## **COUNTY COUNCIL'S RESPONSE TO CONSULTATION ON THE FOLLOWING DEVELOPMENT PROPOSAL**

**Application no:** 21/01224/OUT

**Proposal:** Outline planning application for Automotive Experience Quarter comprising Commercial, Business and Services uses (Class E), Light Industrial (Class B2), Local Community and Learning Uses (Class F) and vehicle circuits (Sui Generis) with all matters reserved aside from that of access).

**Location:** Land at former RAF Bicester, Bicester, Oxfordshire

File: C:\Users\james\OneDrive\OneDrive\Projects\Birmingham2\Project\J323684\_Bicester Heritage Heritage Masterplan16\_Graphics2\_CAD2\_Sheets\191105\_J32-3684-PS-202.dwg

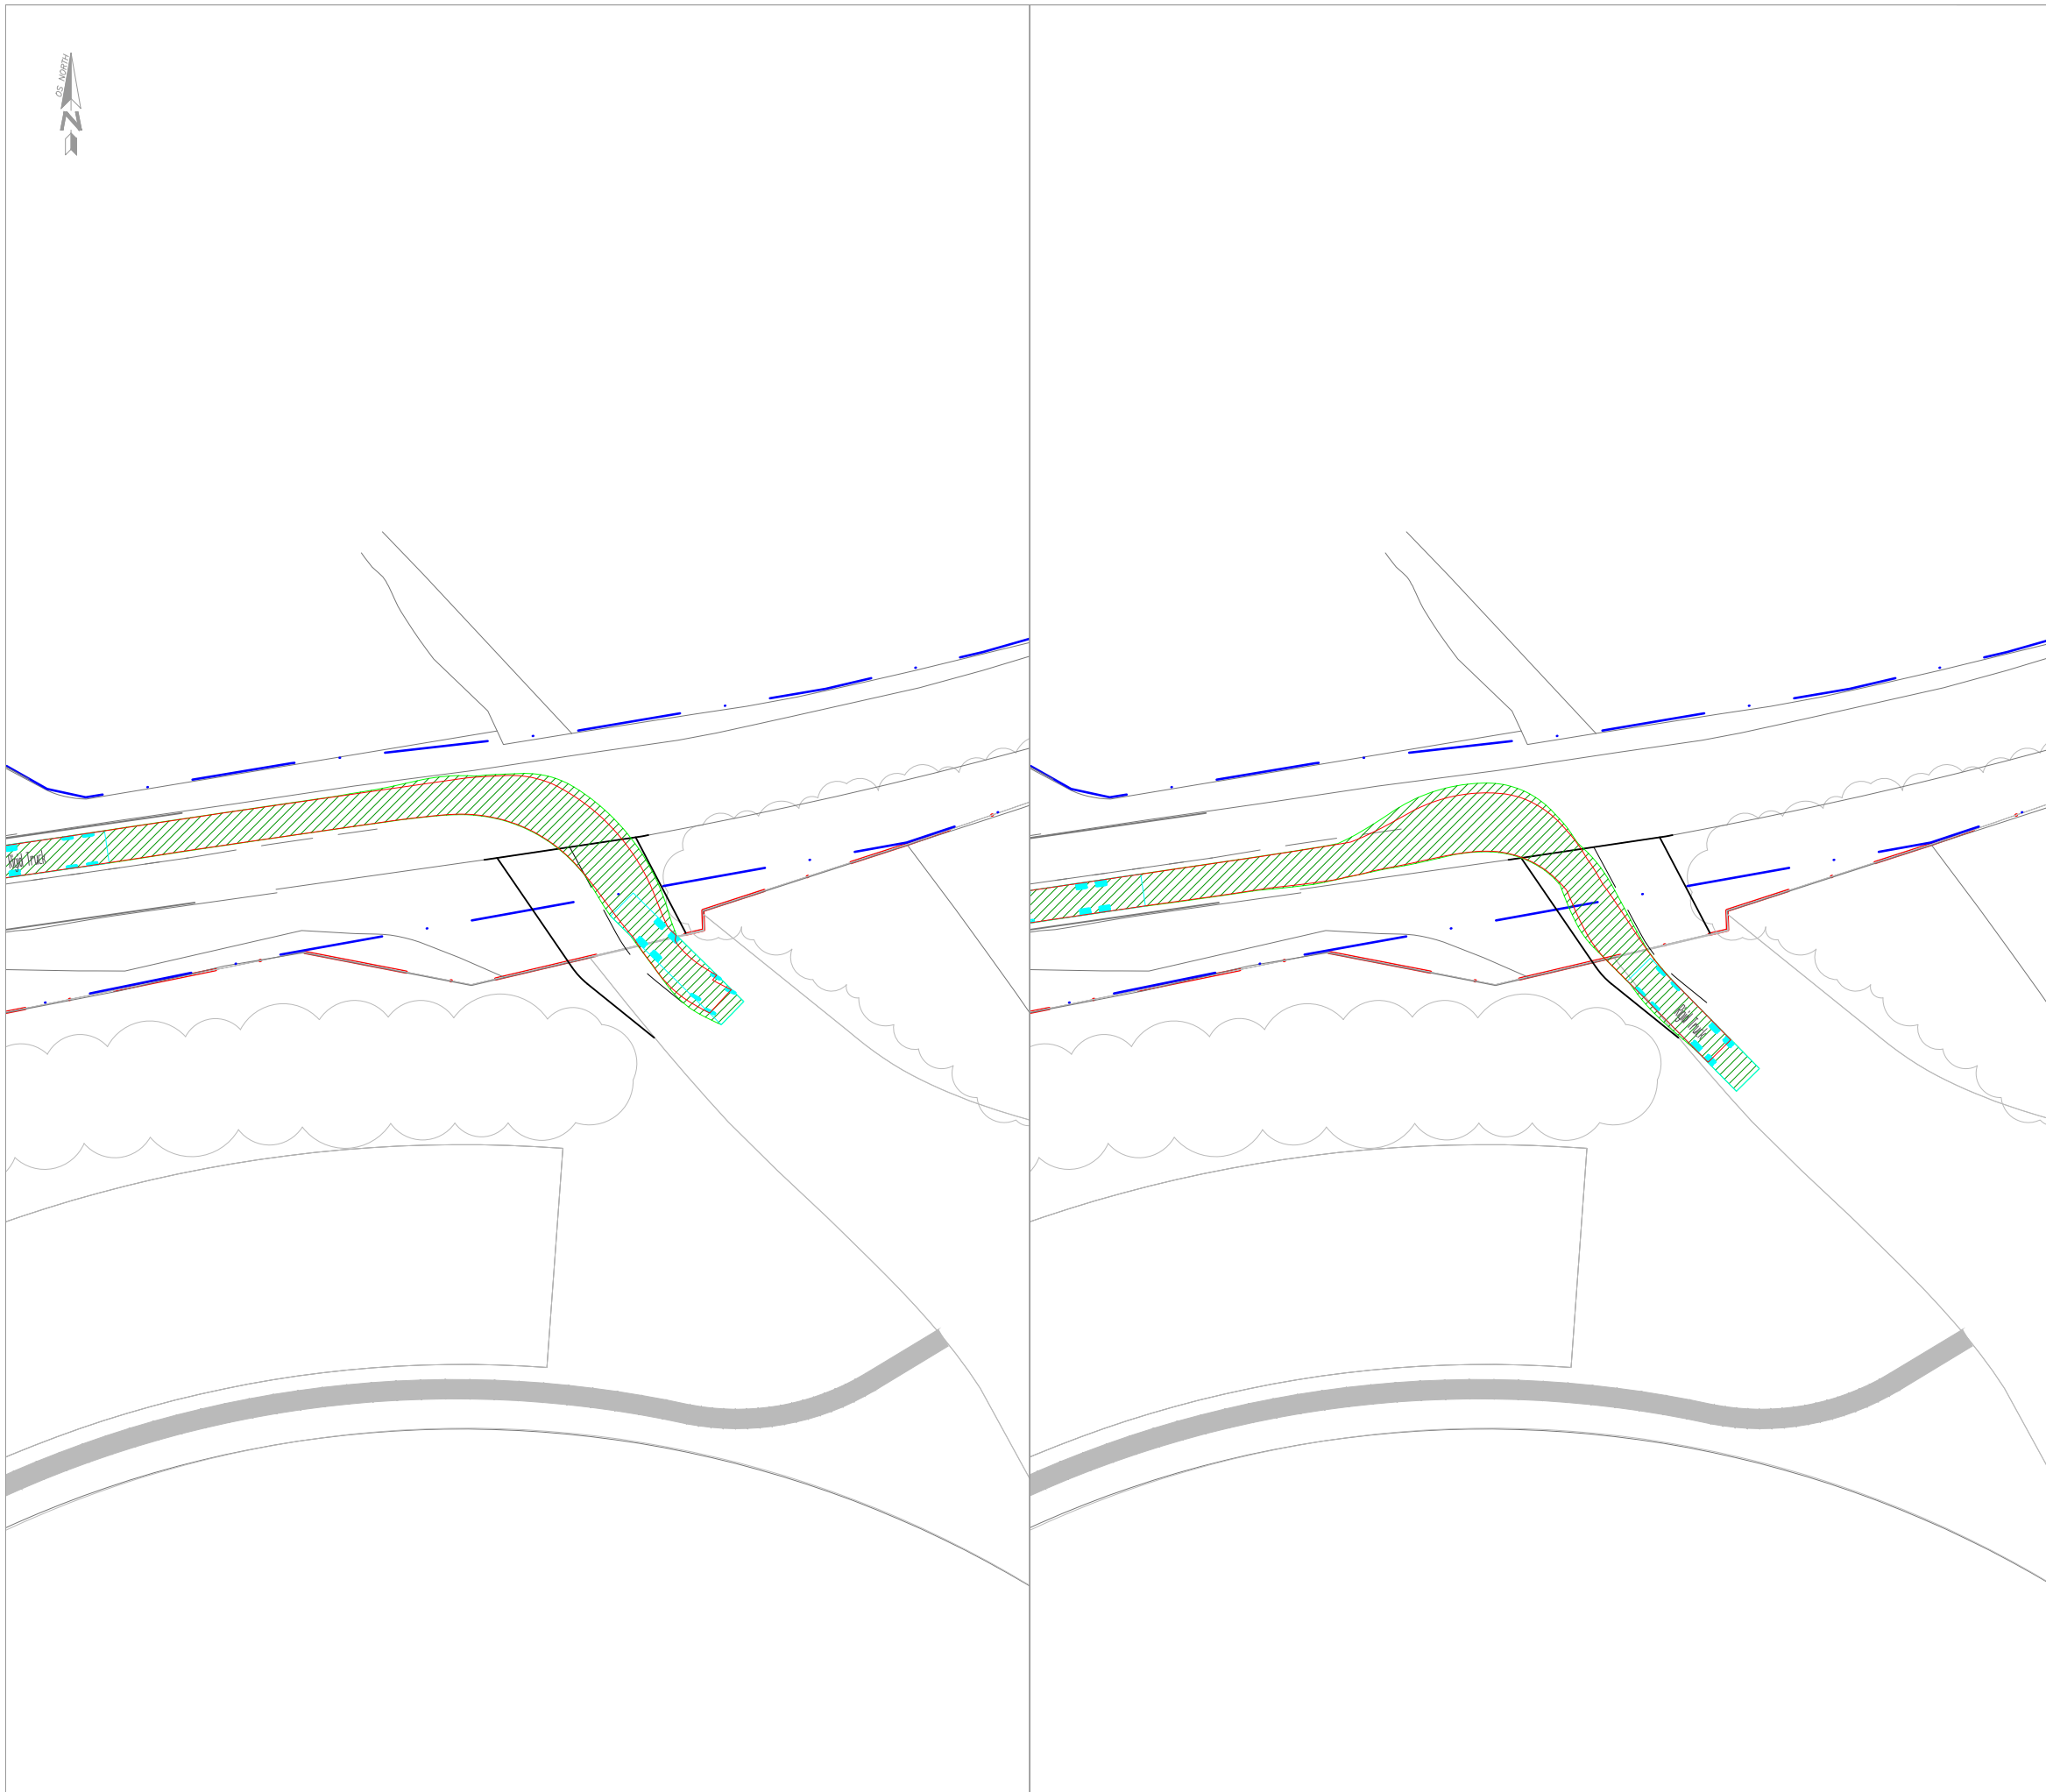
Vehicle tracking has not been provided for any of the proposed / reinstated junctions and this is required in order to demonstrate that the largest vehicles likely to require access to the site can safely and easily enter and exit the site. These details are also required in order to demonstrate safe and suitable access.

The main site access junction is again proposed to accommodate all movements in, but only left-turners out. This means that those leaving the site wishing to head north on the A4421 would need to turn at the Skimmingdish Lane roundabout, c.675m to the south. It is unclear whether a junction allowing all movements has been considered and if so, why this has been discounted. A TRO would be required to enforce the left-turn exit from the site and the junction would need to be designed to prevent right-turns.
